FORMAL OBJECTION TO PLANNING AMENDMENT [2025/70/91279/E]

Land off Kenmore Drive, Cleckheaton

Addendum (Response to Applicant Rebuttal – Document 1105899)

6 October 2025

ASHP & EXTERNAL PLANT ENCLOSURE PLAN - Scale 1:50

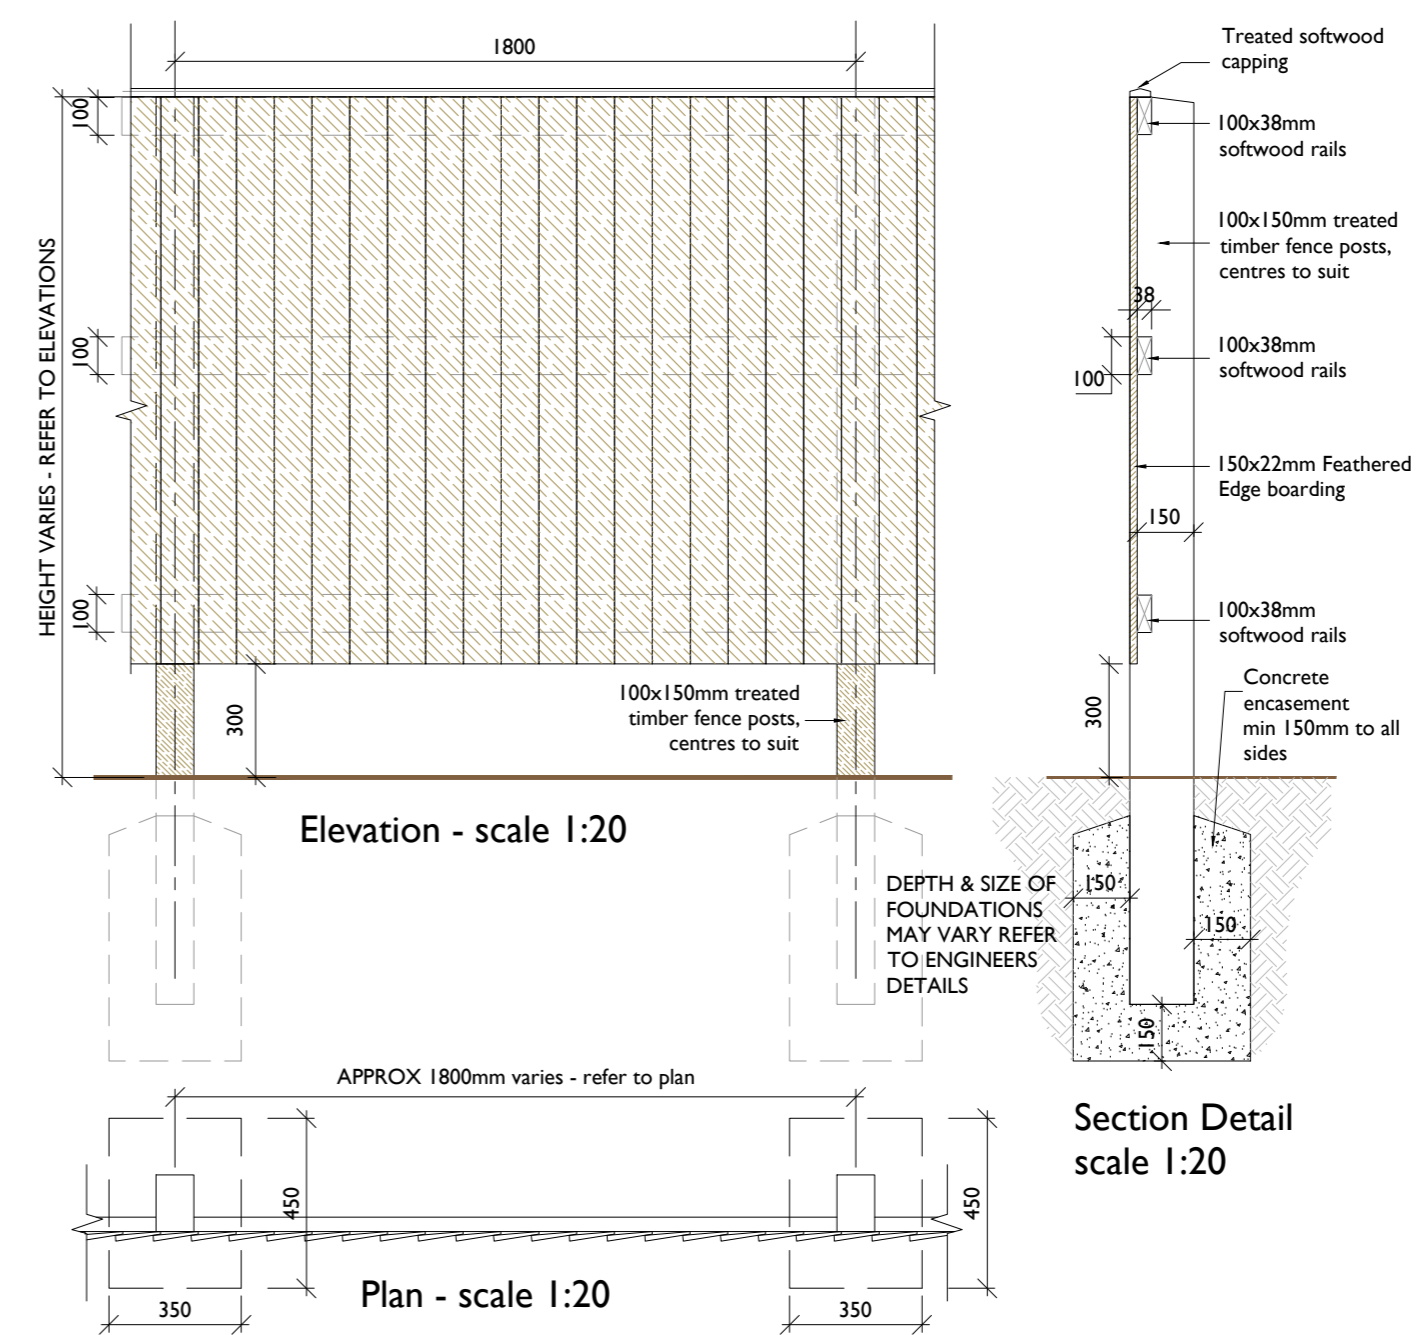
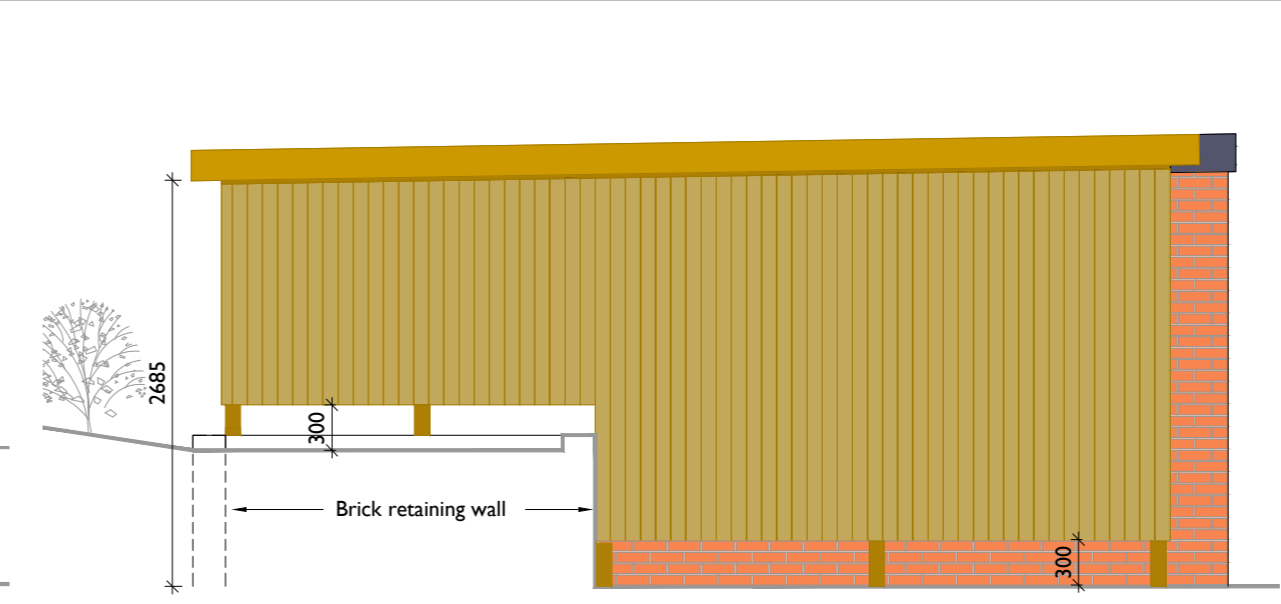
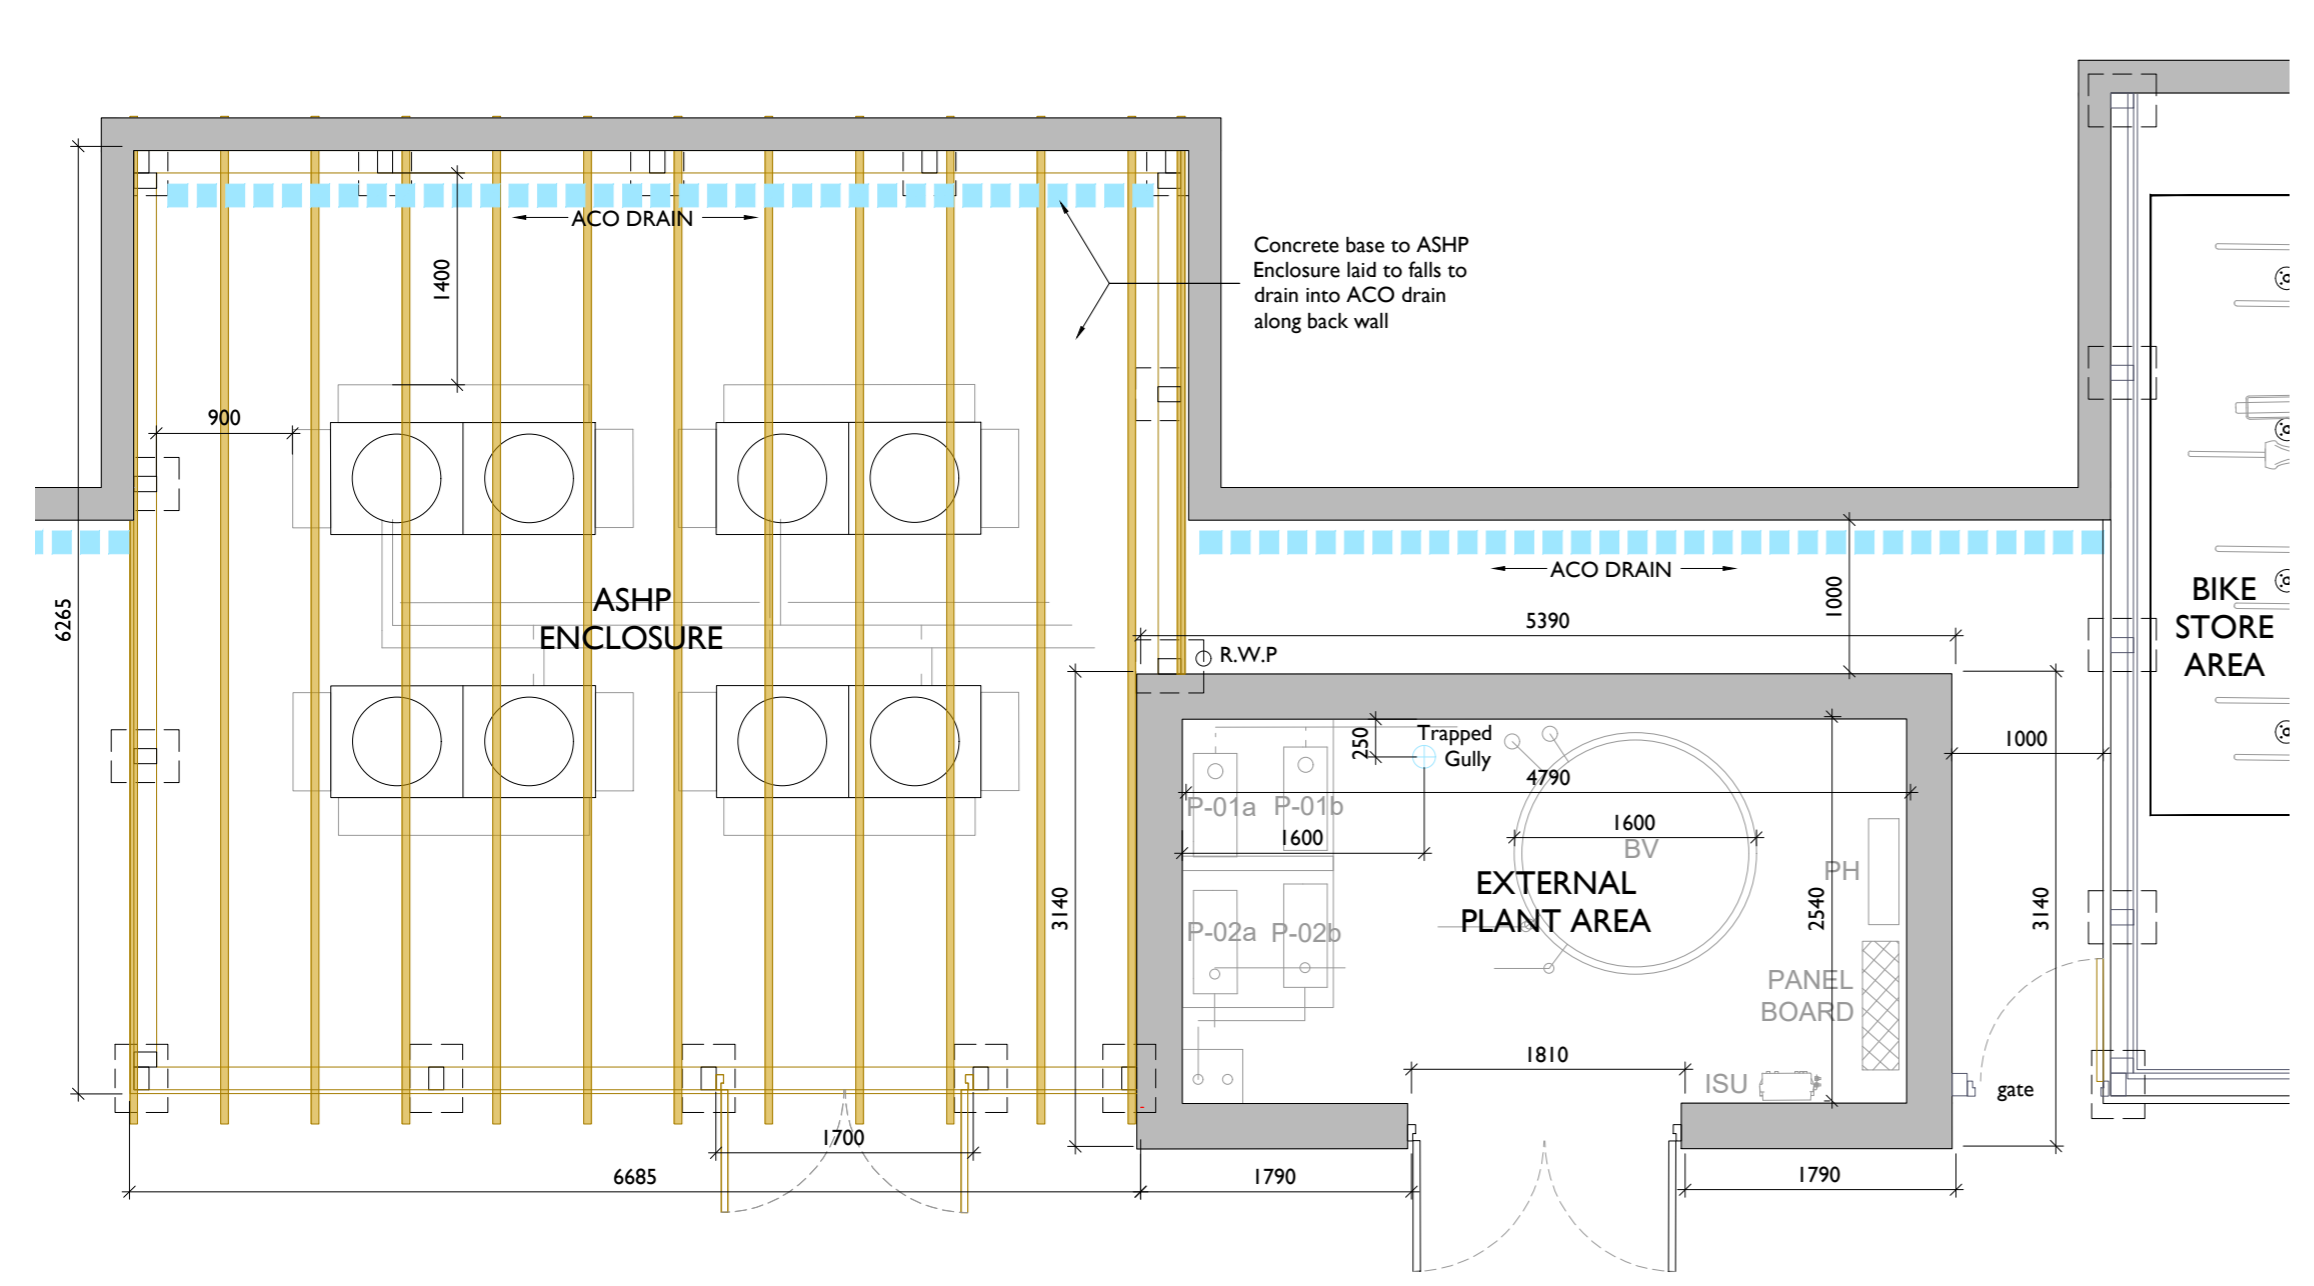
5. Equipment Relocation and Enclosure Design

The developer rejects Mitigation Option 1 (relocation) based on “maintenance and access” grounds, rather than acoustic or planning considerations. These are operational conveniences, not constraints that can override residential amenity.

Furthermore, their statement that a fully roofed compound would require a 4 m structure confirms that the existing design is already over-constrained and acoustically compromised, supporting my previous concern about the “slot-canyon” amplification.

This reinforces that the compound is not suitable for this site configuration.
